**Re: Innova Plaza South Building,  
401 Eubank Blvd. SE Albuquerque, NM  
Request for Certificate of Occupancy  
Transportation Development Final Inspection  
Engineer's/Architect's Stamp dated 03-03-2017 (L20D067)  
Certification dated 02-12-2018**

Based upon the information provided in your submittal received 11-21-2018, Transportation Development cannot approve the release of Certificate of Occupancy for the above referenced project.

REVISION DATE

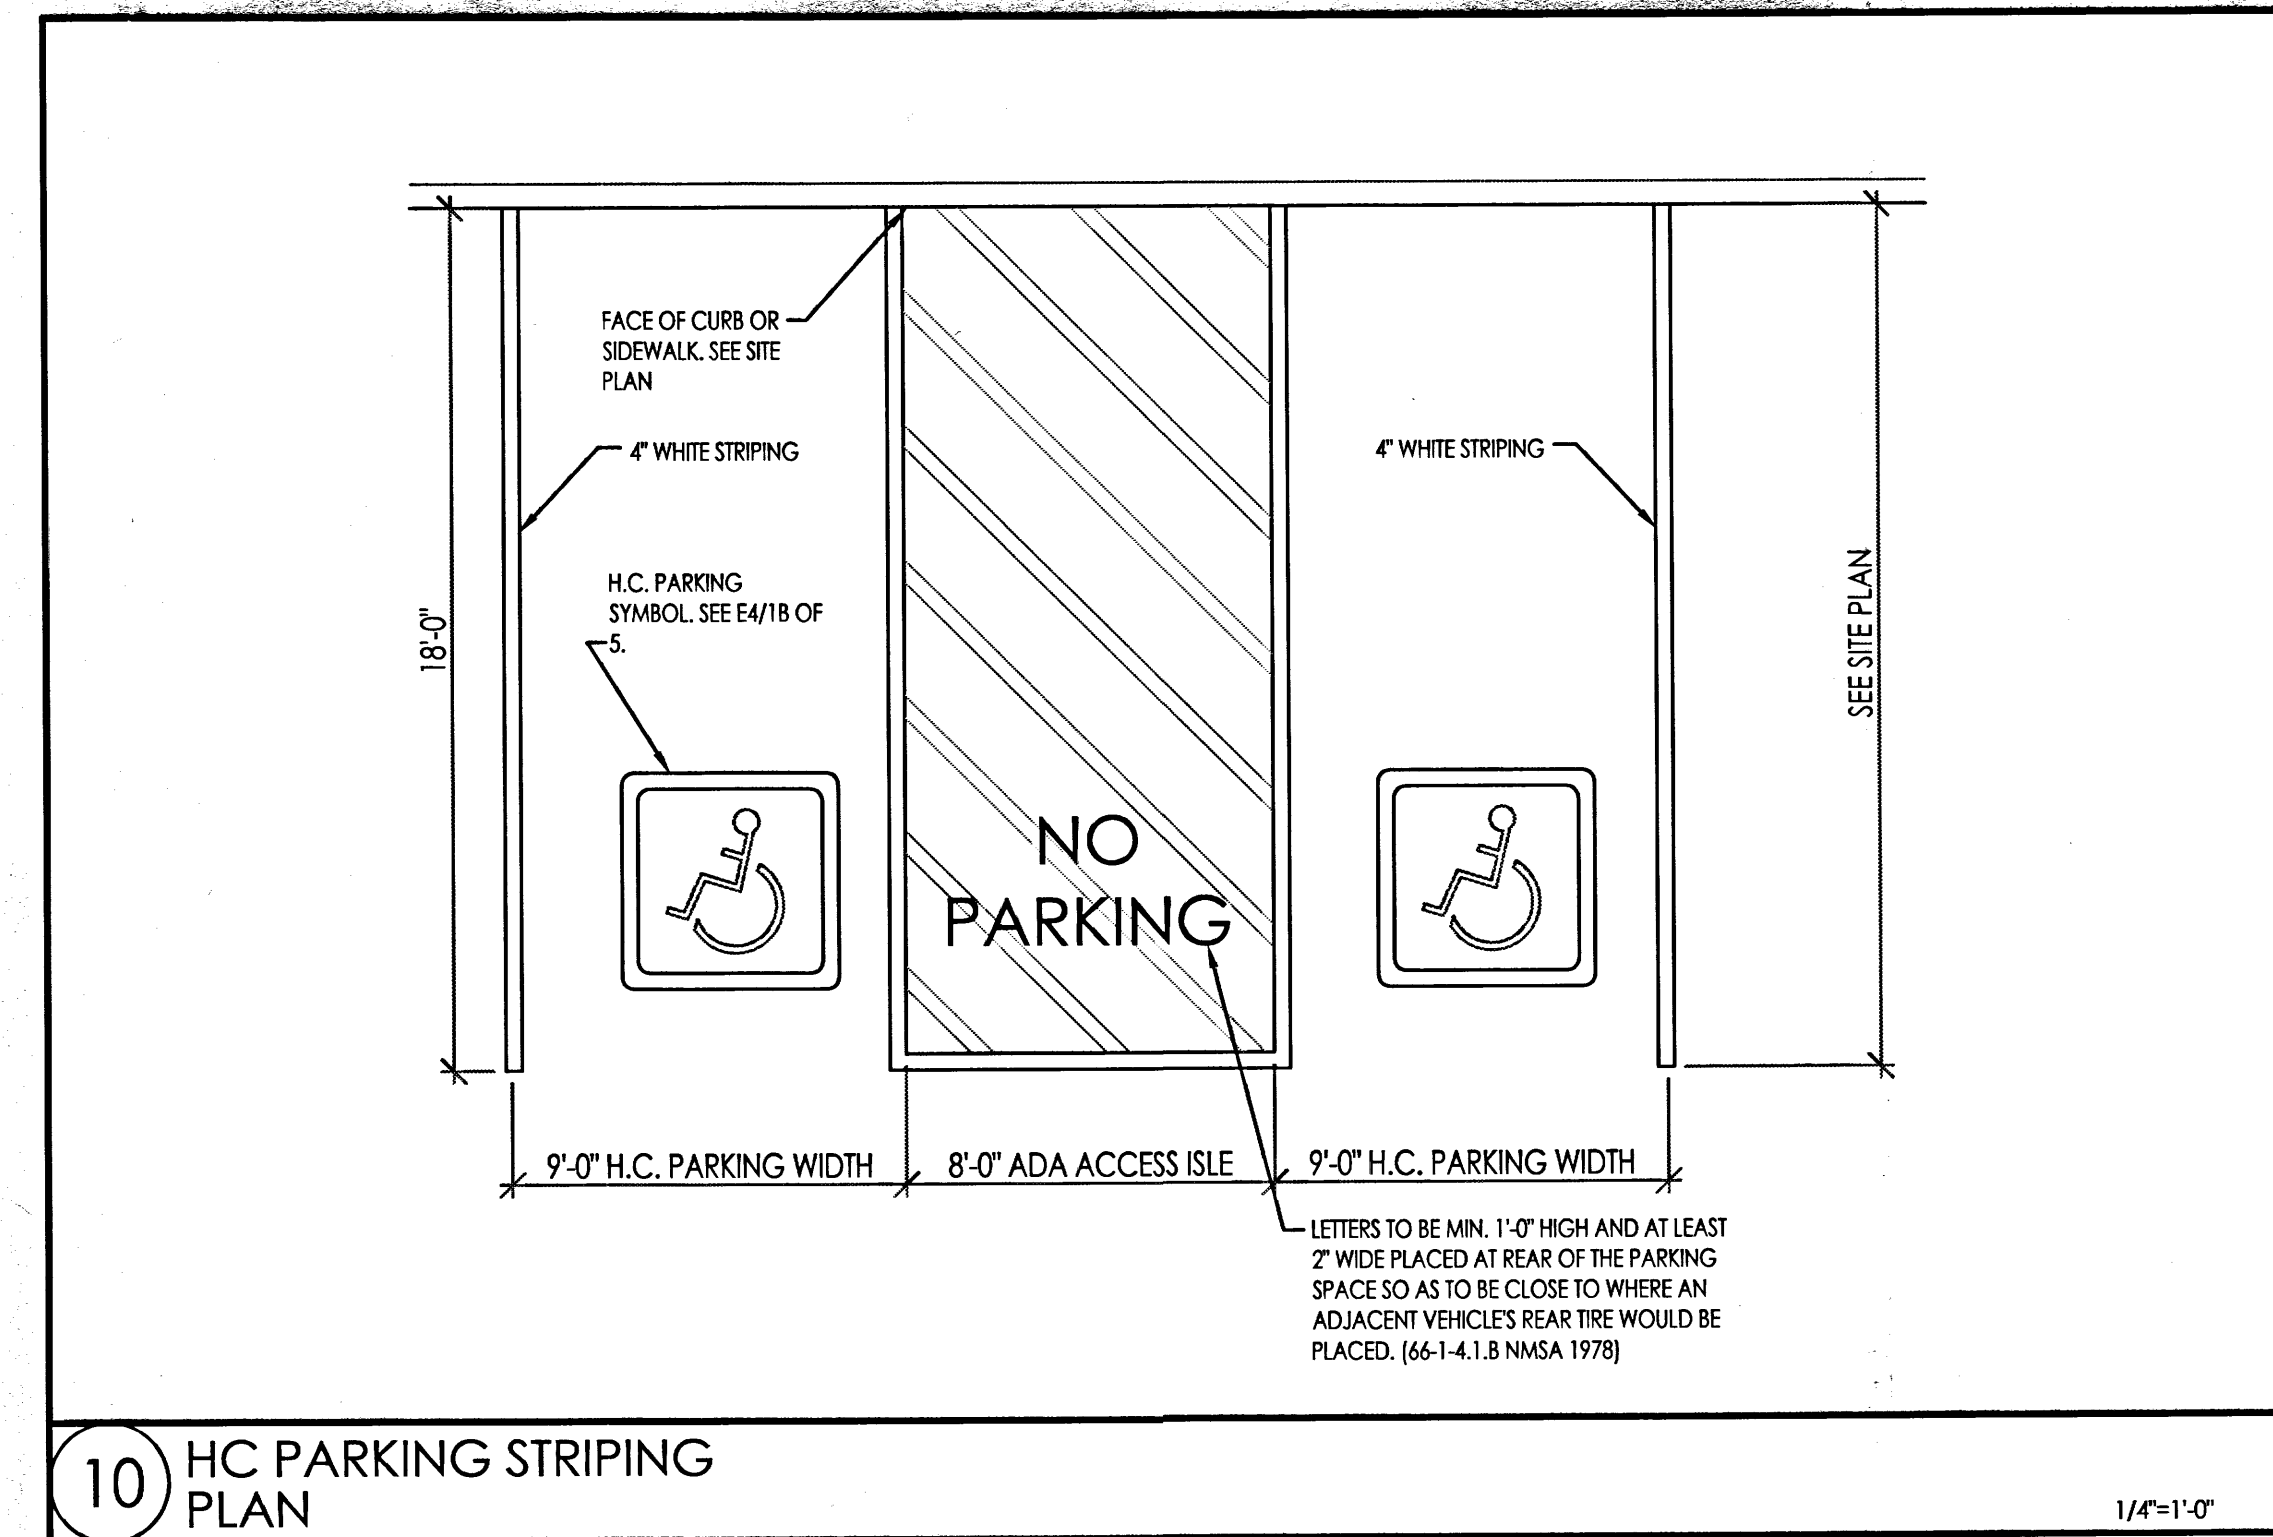
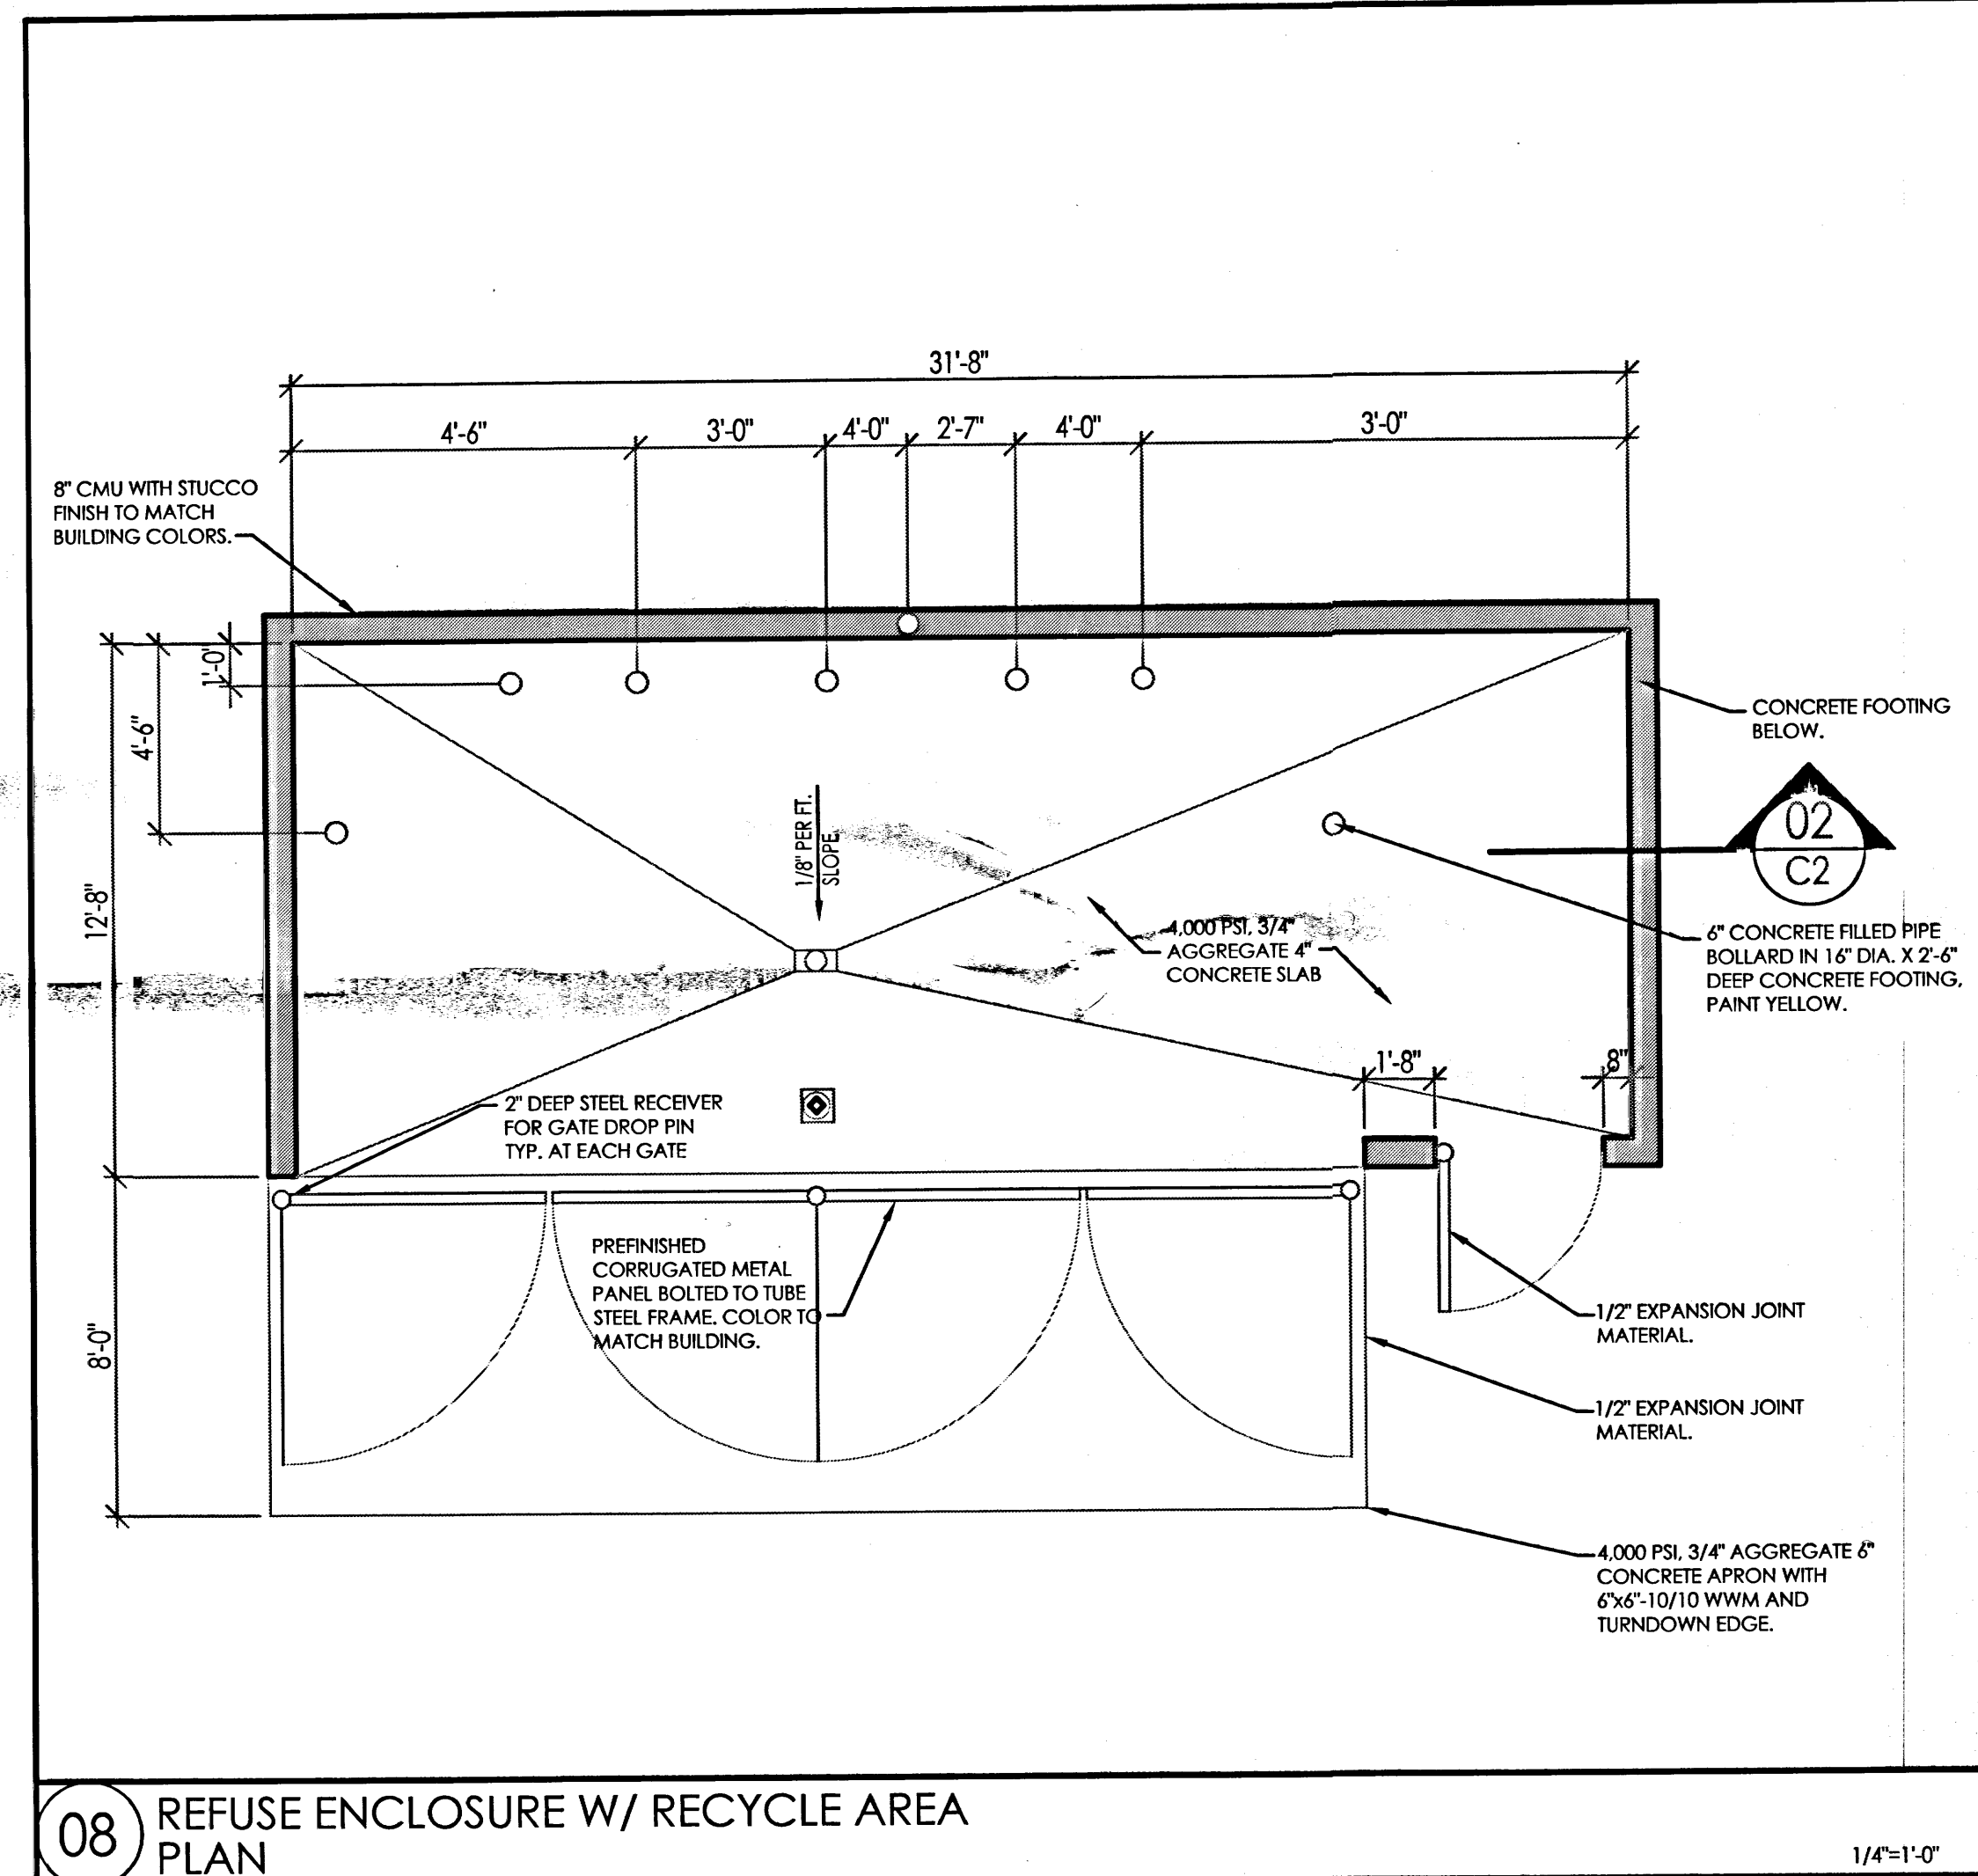
- Please clear the site of all the debris
- Please install a pedestrian access connecting the side walk to the building the same way it was approved in the original submittal on 03-14-2018.
- Please make sure all the striping are the same as the original submittals.
